The Planning Department
Arun Civic Centre
Maltravers Road
Littlehampton
West Sussex
BN17 5LF

1 October 2012

**Planning Application – 65 Golden Avenue, East Preston, BN16 1QU
Reference K-15-12**

SECTION B - B

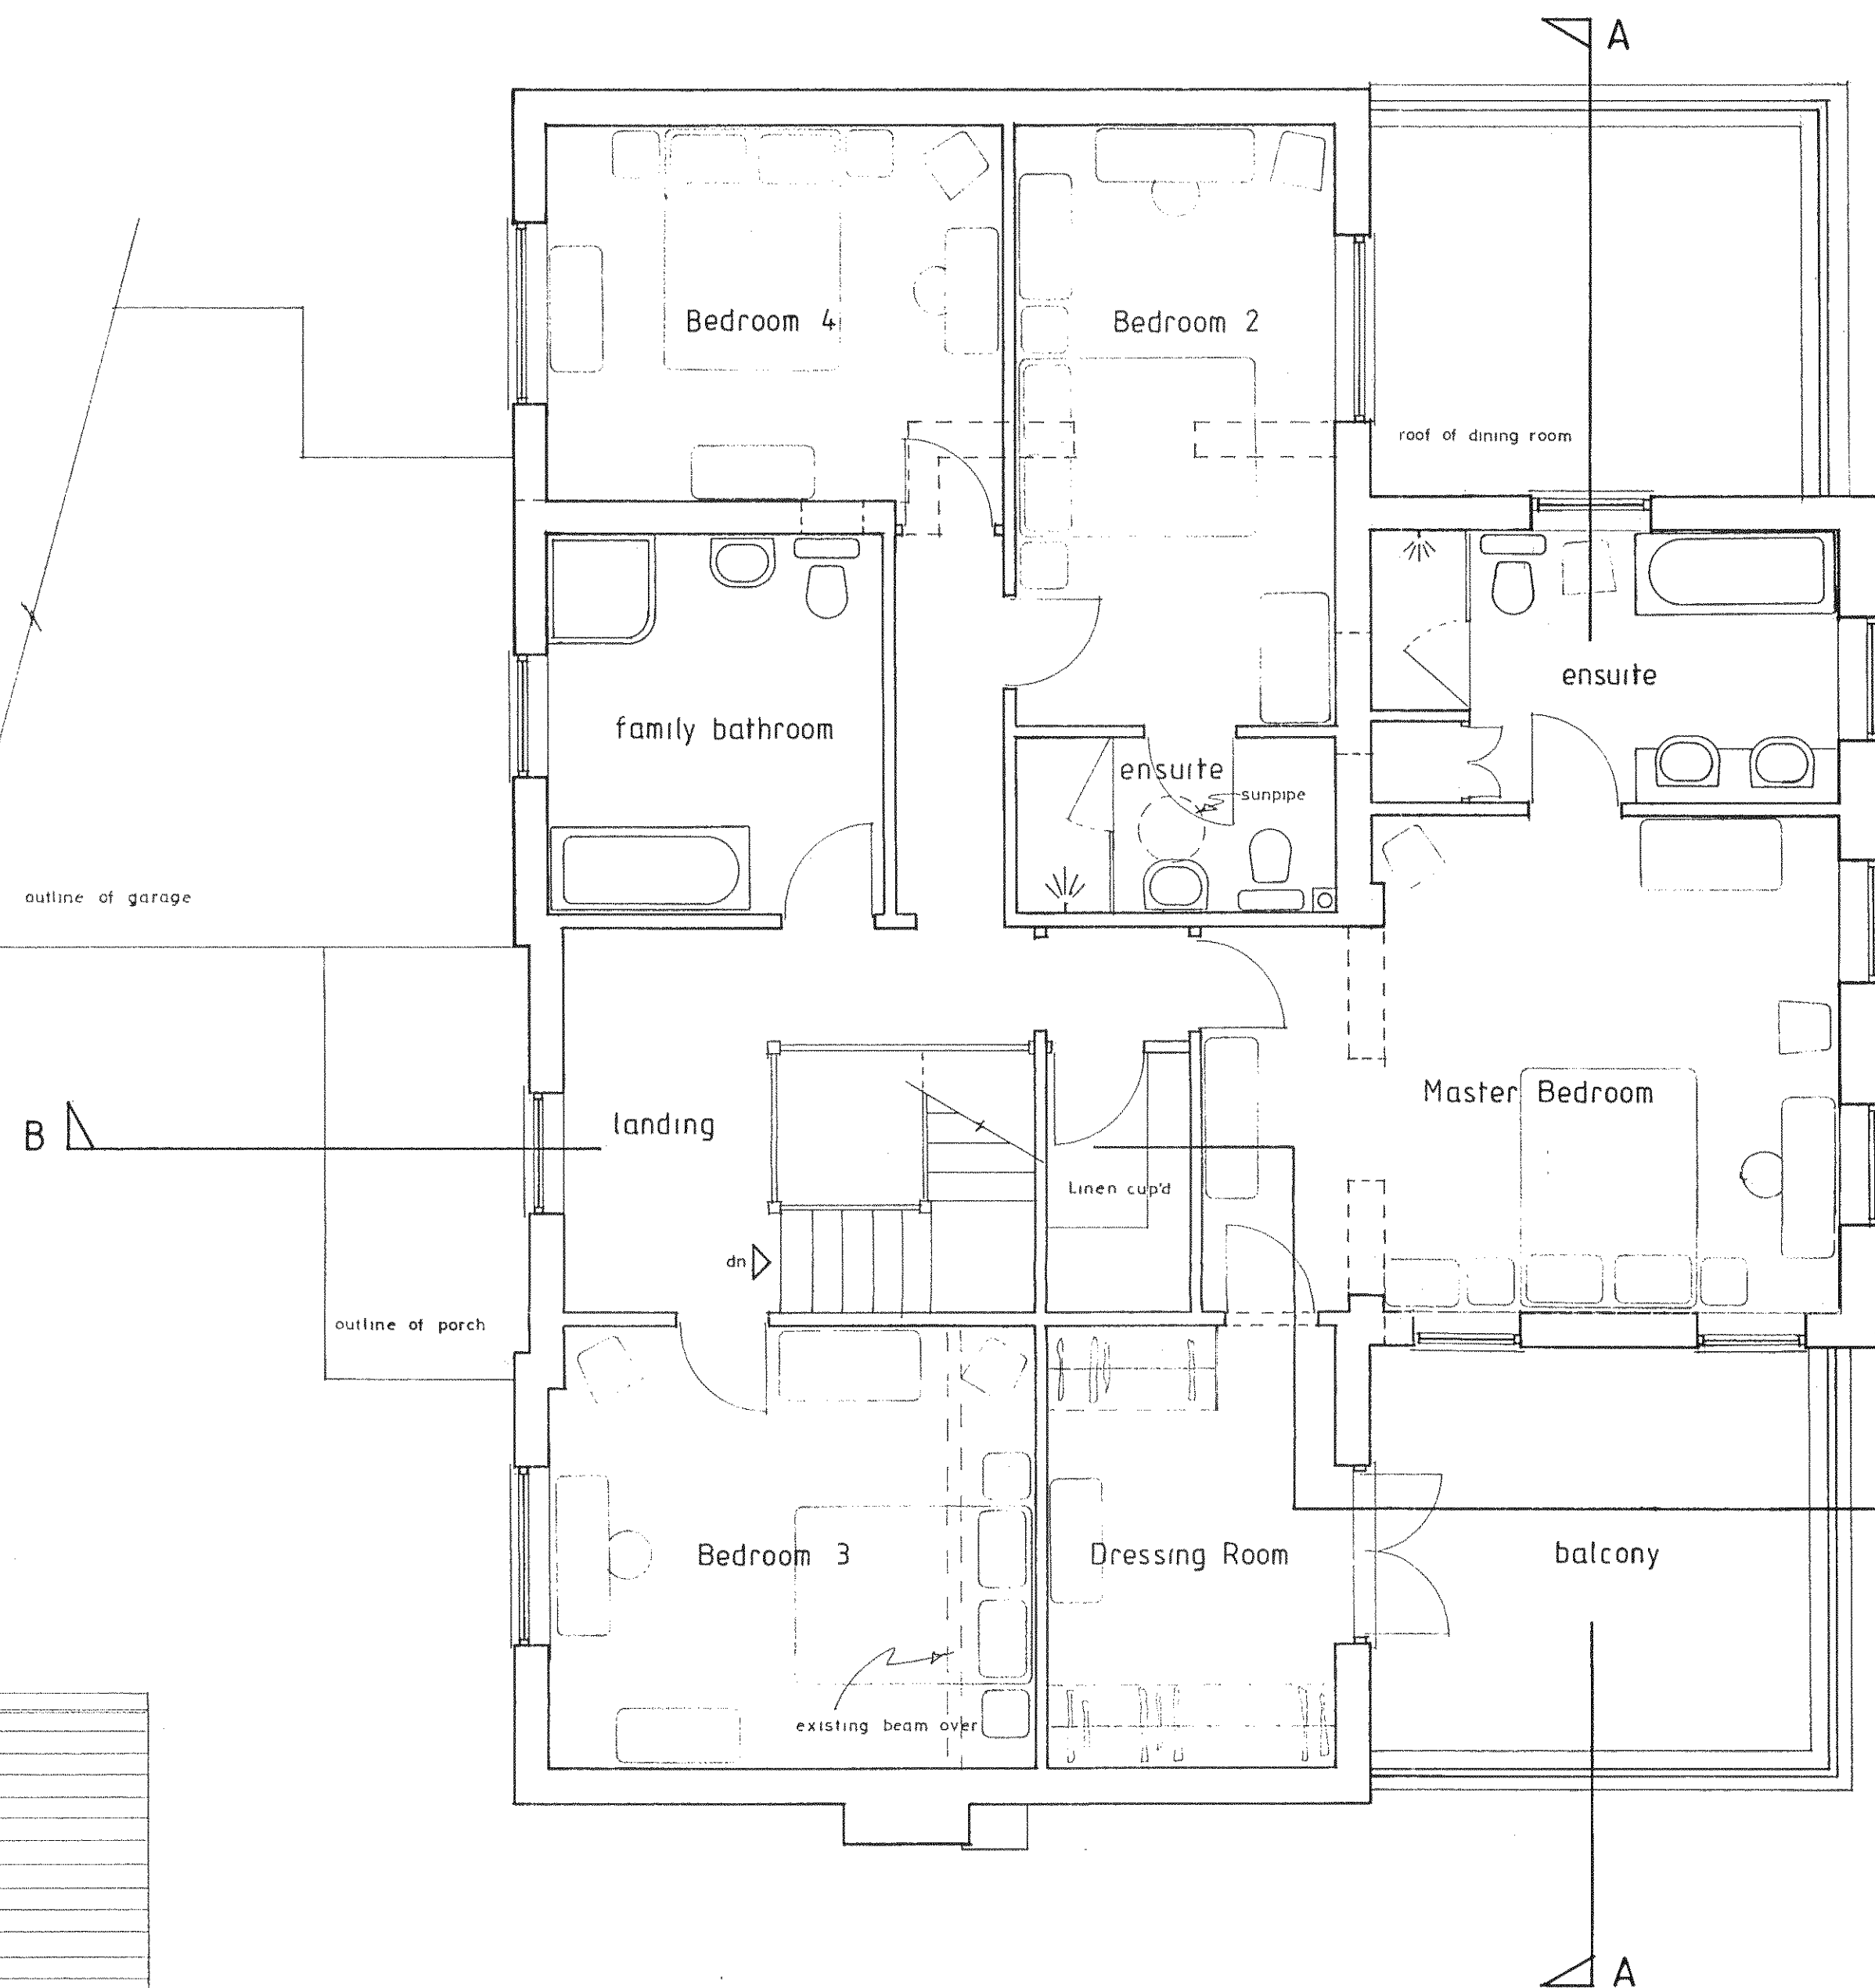
Whilst we do not oppose the planning application to the above property, we would like the windows that face south on the proposed balcony (from what we understand to be the principal bedroom), to either be replaced with a high level window(s) or the windows to be opaque glass.

These windows, we believe, will look directly down into our conservatory where we spend a lot of time all year round.

We could say the same about the proposed balcony but, in practice, we do not envisage that the balcony will be used much.
